North Carolina Department of Transportation

NEPA/SEPA Consultation Form

STIP Project No.	BR-0032
WBS Element	67032.1.1
Federal Aid Project No.	N/A

G. Consultation Approval for NCDOT Project BR-0032

PLAN OF 30' UNIT (SPAN A)

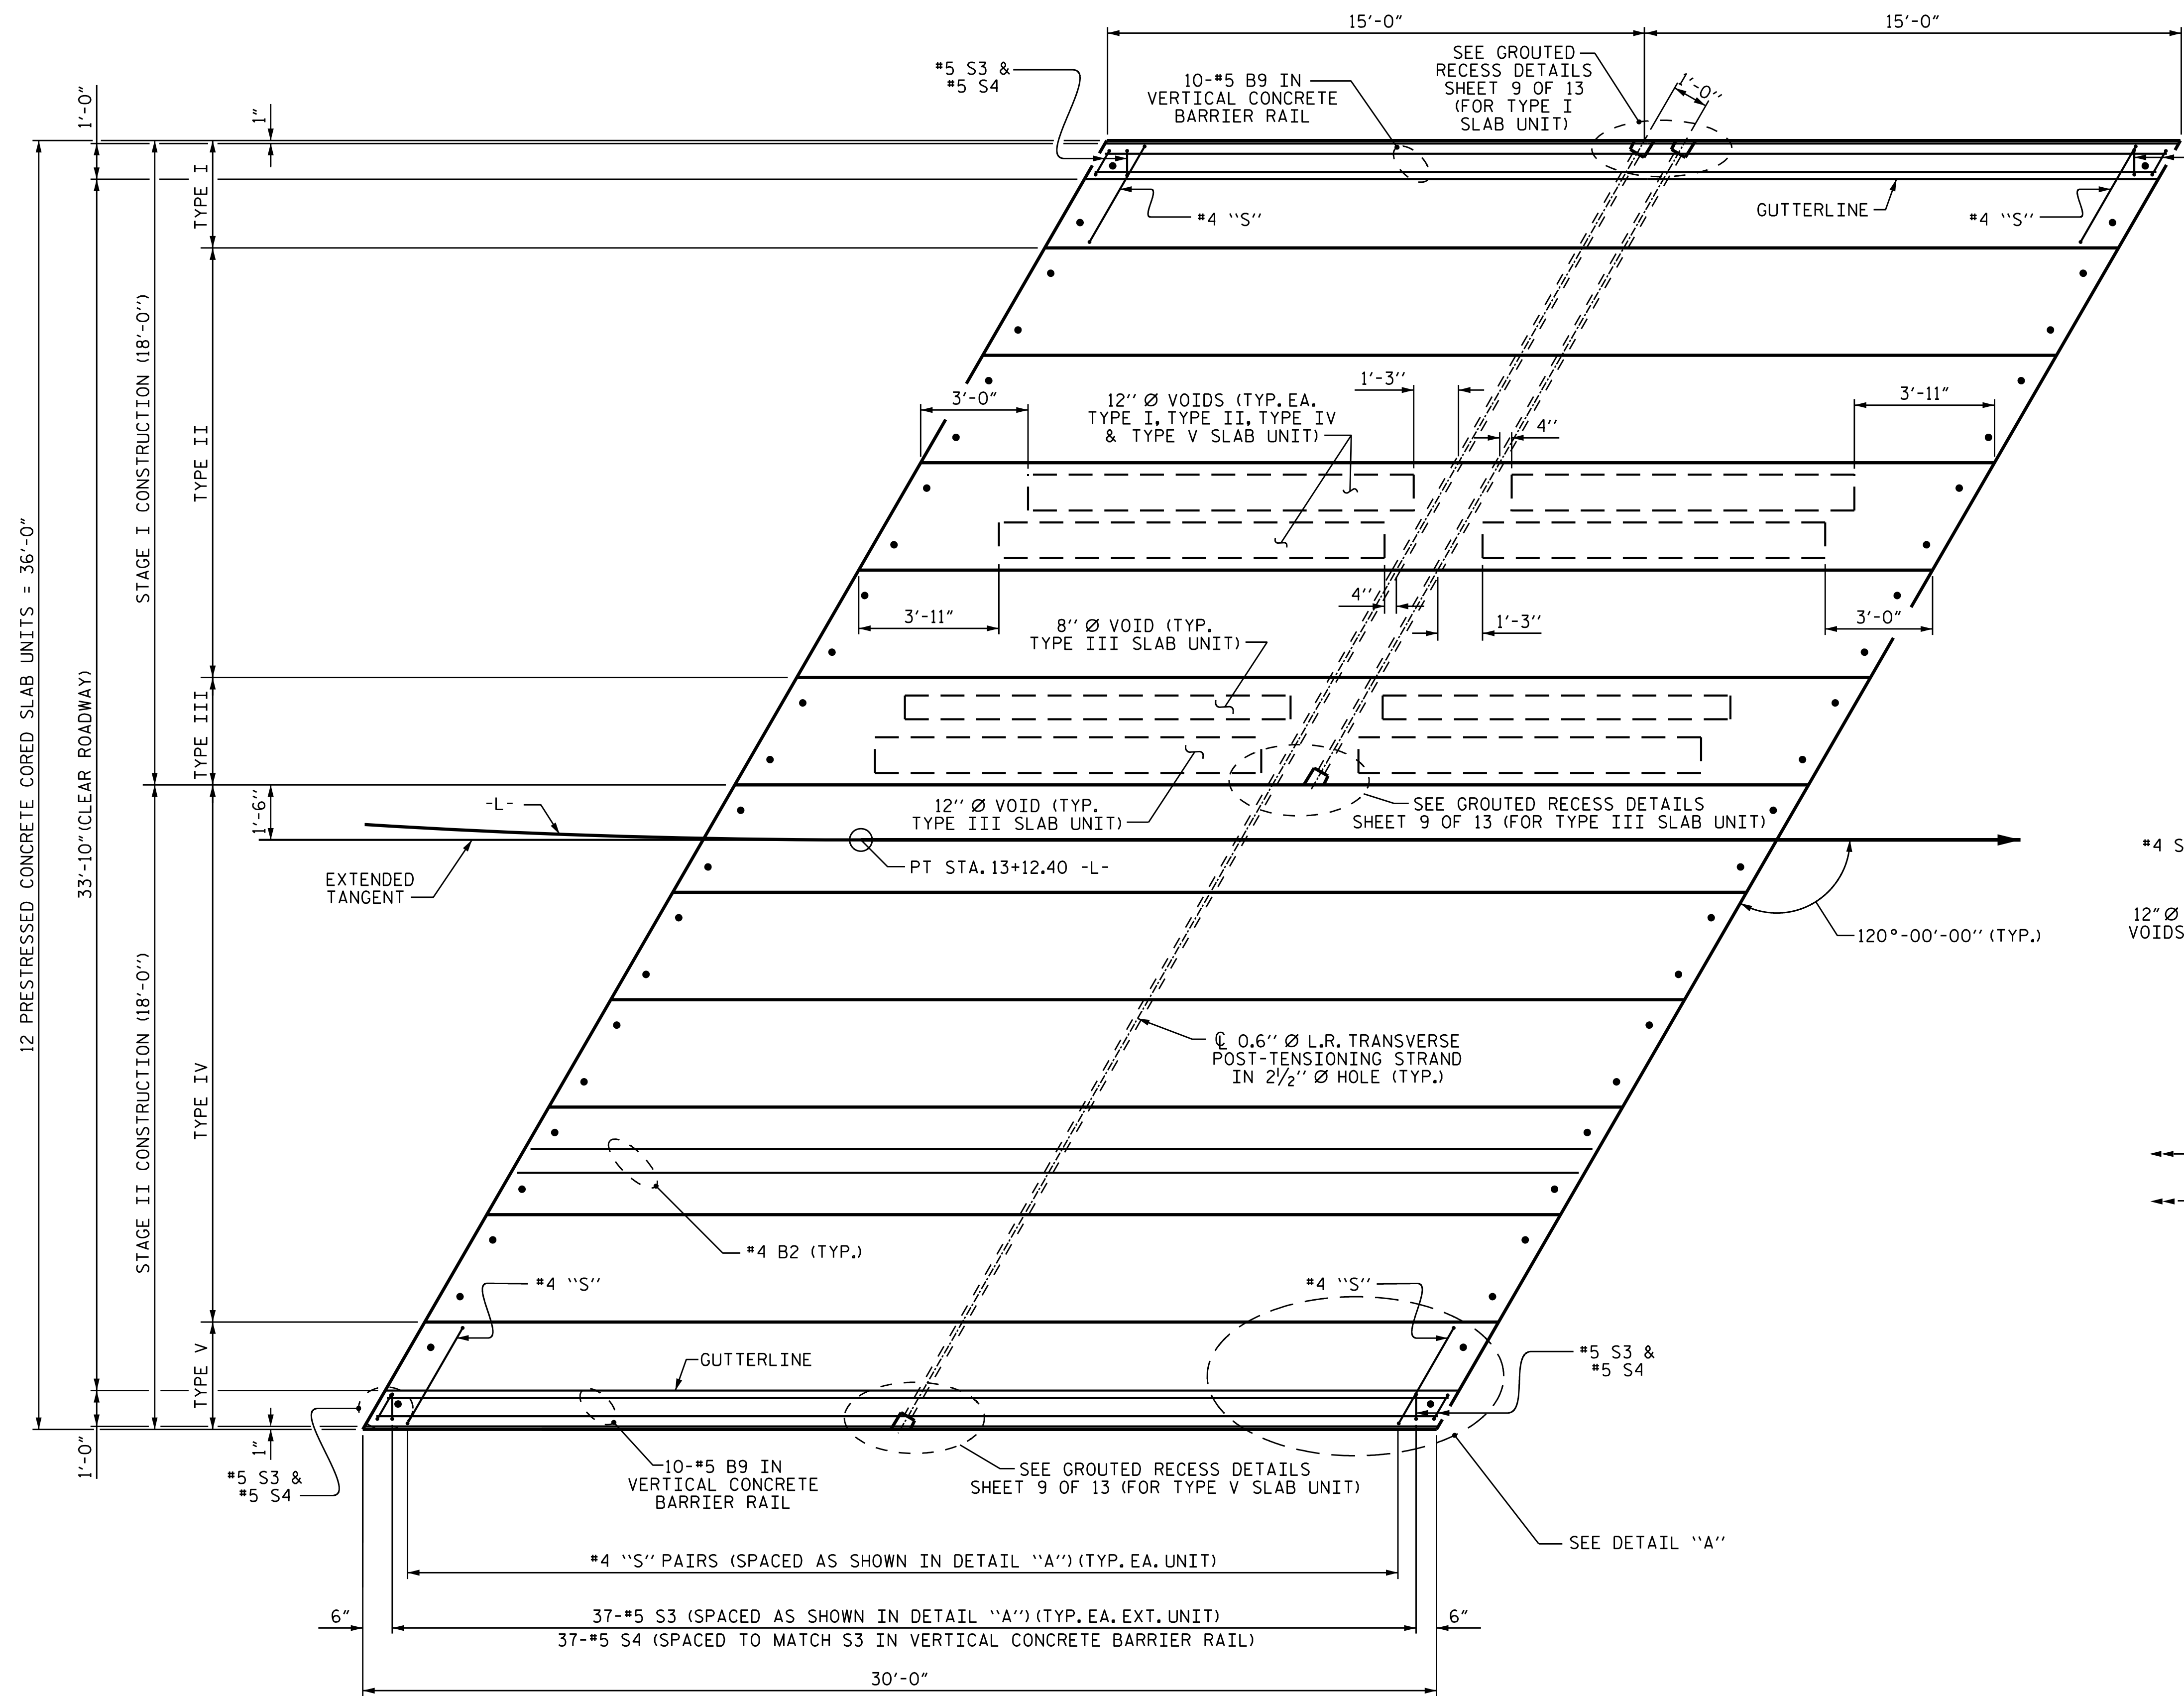
The proposed bridge length has been revised from a 70-foot long, single span, 24-inch cored slab bridge to a 103-foot long, two-span bridge (1 @30'21" cored slab, 1 @70' 24" cored slab). As noted above, the bridge design was revised from one span to two spans to allow for the elimination of the retaining wall near End Bent 1.

PLAN @ END BENT #1

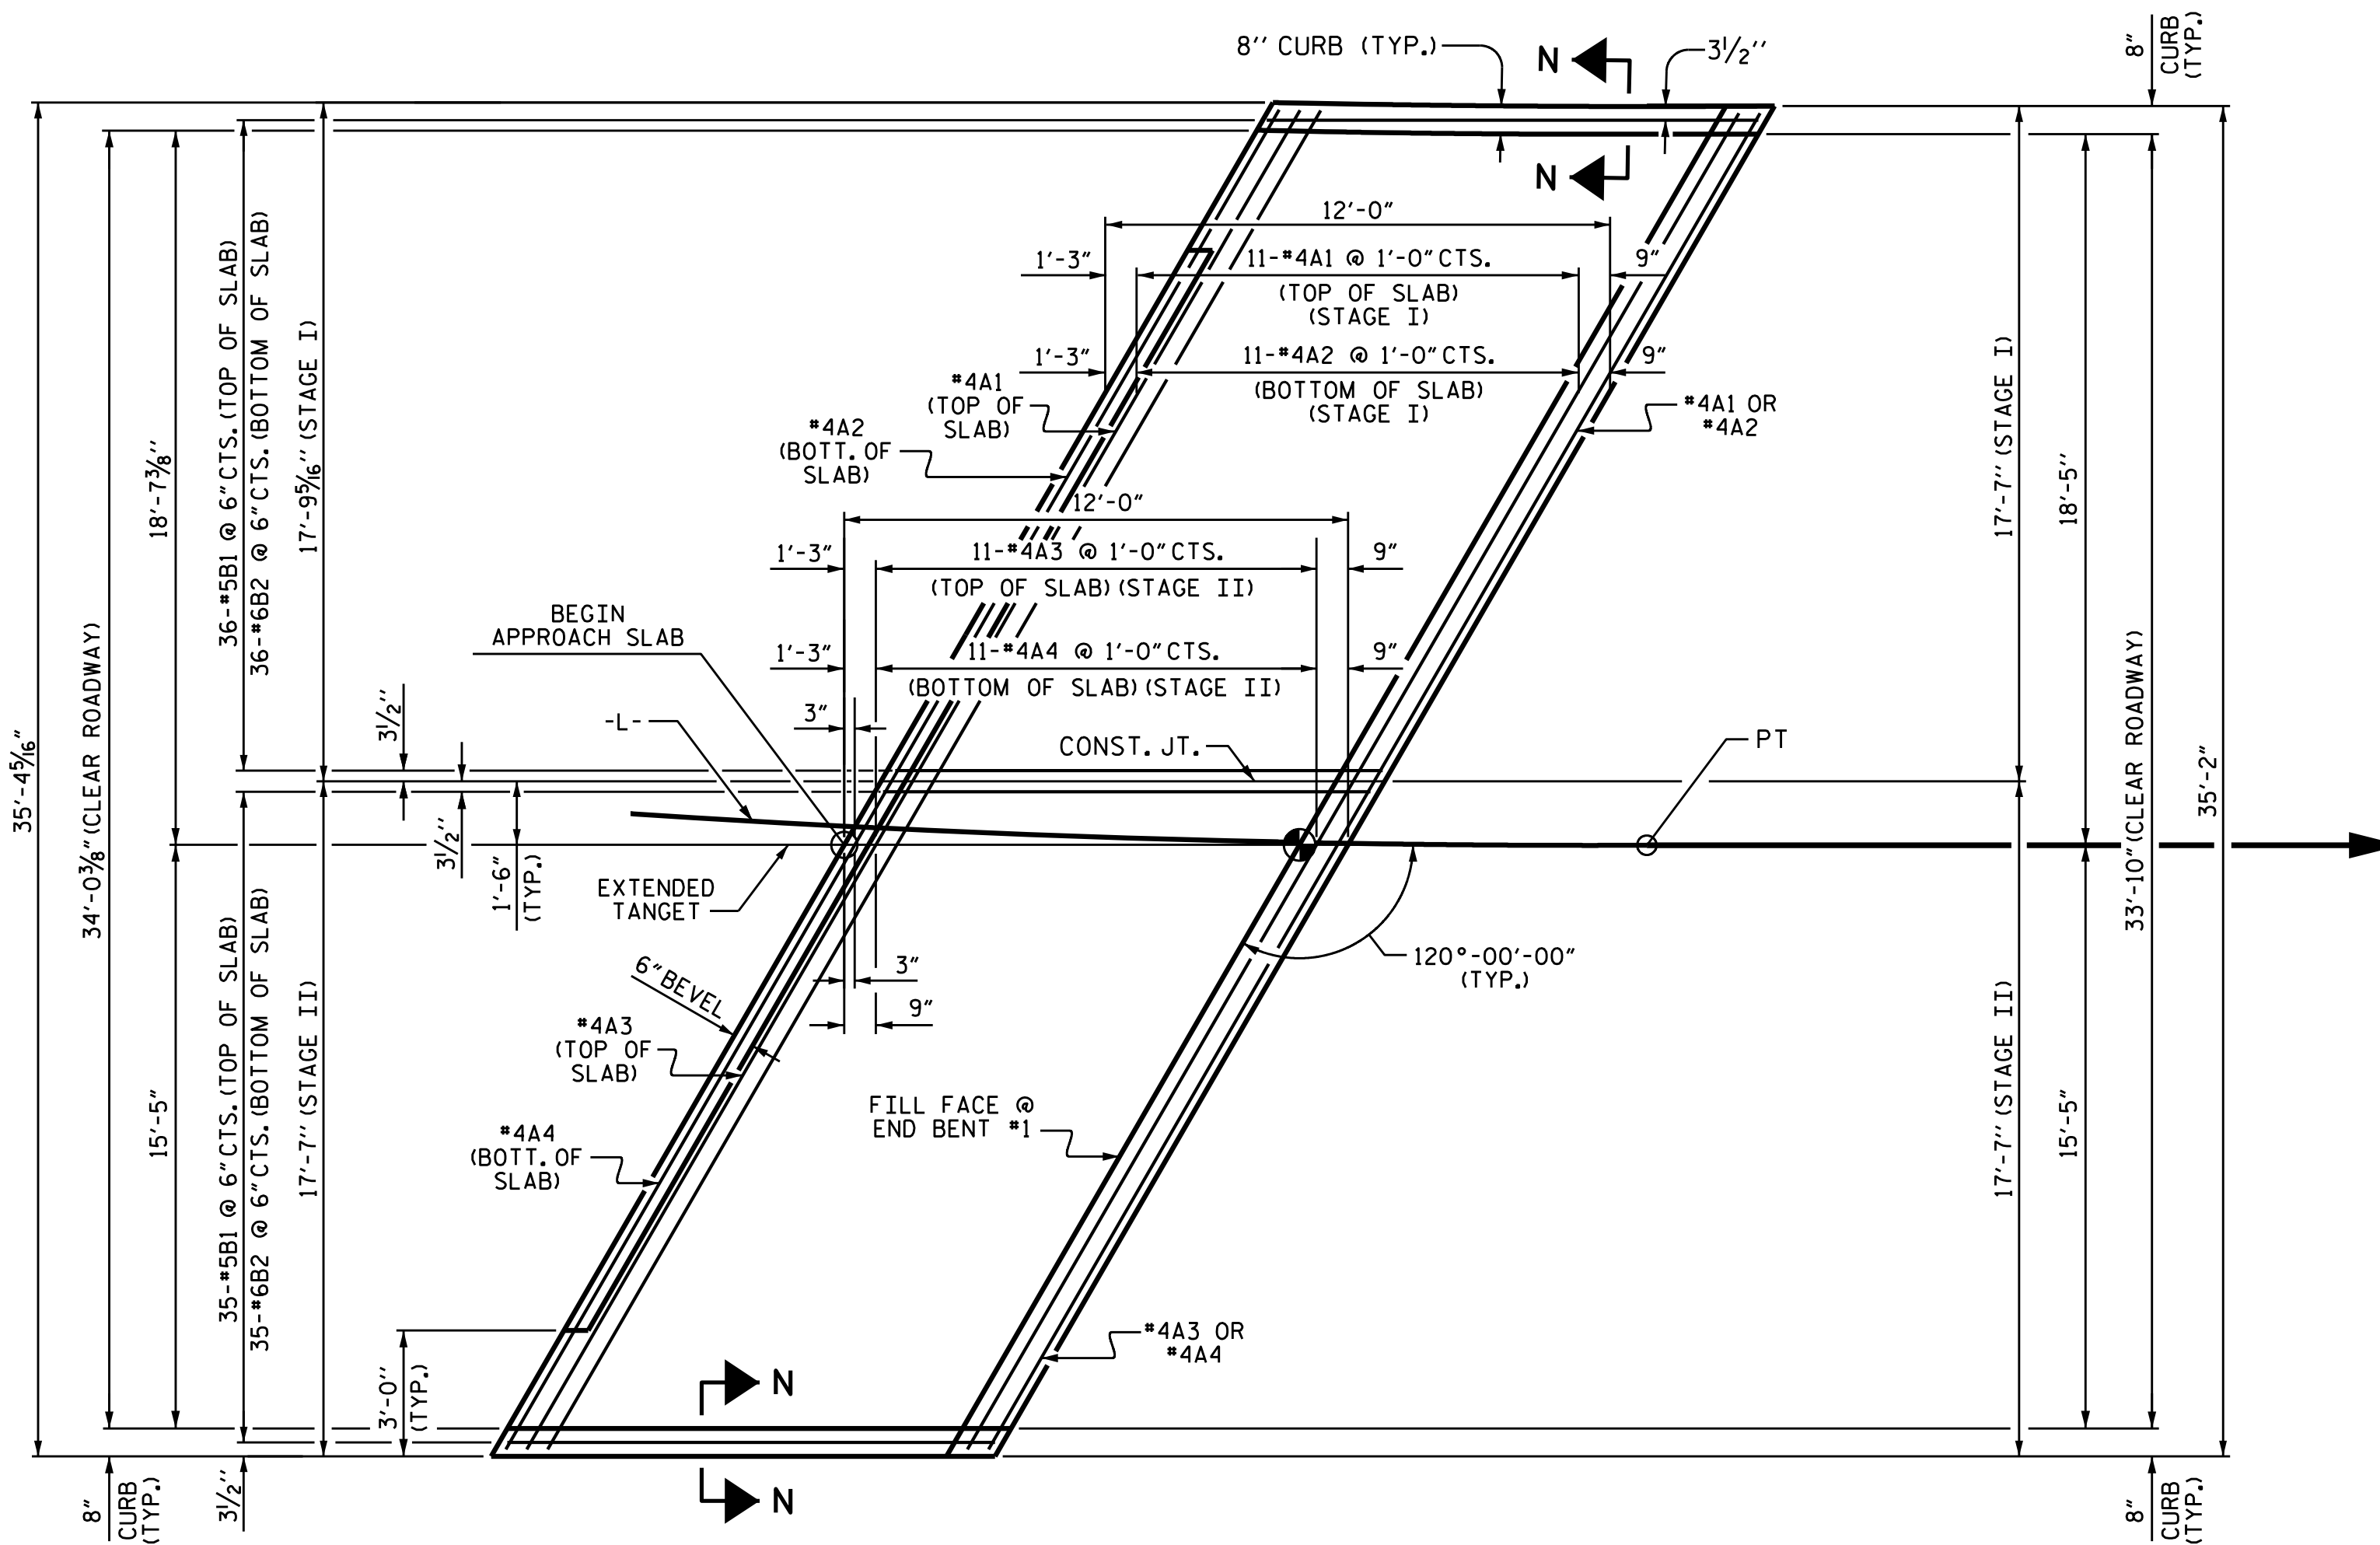
The original plans included a retaining wall that began approximately 50 feet west of the bridge, near End Bent 1. Due to concerns with the constructability and long-term maintenance of the proposed wall at End Bent 1, NCDOT Geotechnical Foundation Design Unit and NCDOT Structures Management Unit requested that this retaining wall be eliminated. To accommodate this change, the bridge design was revised by lengthening the bridge from 70 feet to 103 feet and increasing the number of spans from one to two, as described below.
